from
**Southern
Water**

Date
20/04/2022

Proposal: Erection of 167 No new homes in a mix of 1-4 bedroom properties (2-4 bedroom homes and 1 bedroom apartments), with associated landscaping, parking, open space, play areas, construction of a new vehicular access from Golfers Lane and all other associated development works (resubmission following A/129/21/PL). This application is a Departure from the Development Plan and is in CIL Zone 3 and is CIL Liable as new dwellings.

Site: A/45/22/PL: - Rustington Golf Centre, Golfers Lane, Angmering, BN16 4NB.

Appendix A - Site Layout

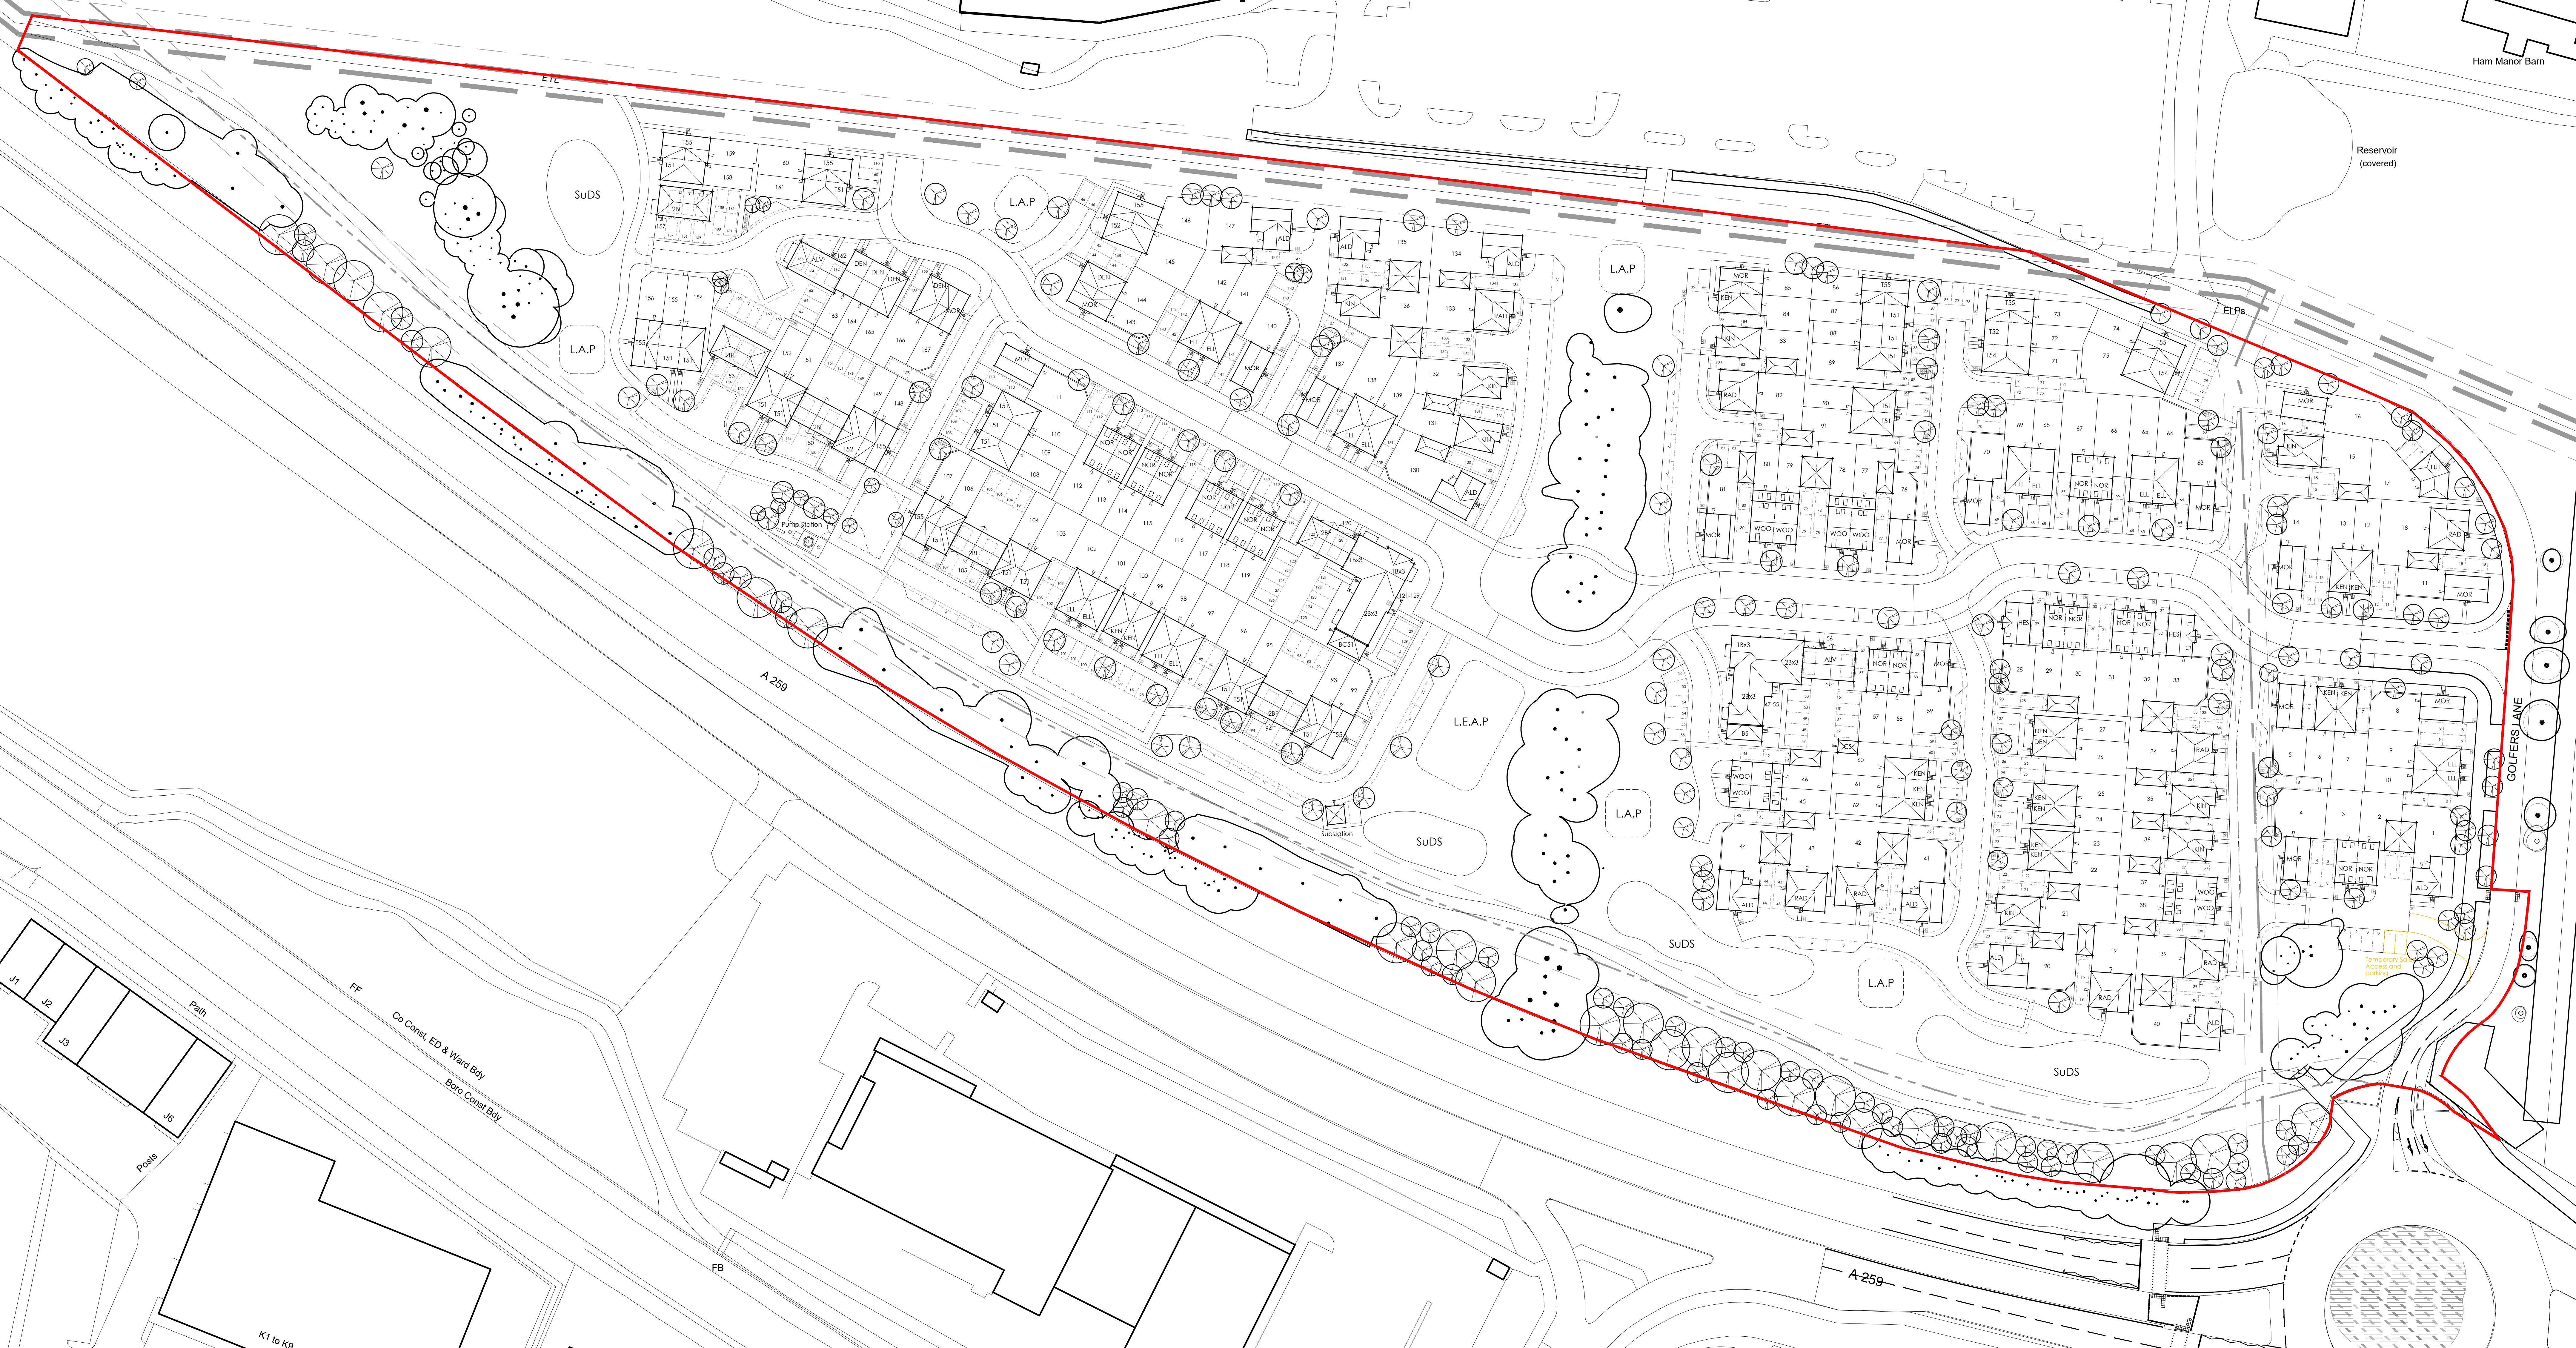
Please note: The proposed road works above the public rising main is not acceptable by Southern Water. No excavation, roads work, mounding or tree planting should be carried out within 3.5 metres of the external edge of the public rising main sewer without consent from Southern Water.

The developer needs to submit a revised site layout indicating the standoff distance from the public rising main sewer or a diversion application for the public rising main sewer under S185 of Water Industry Act.
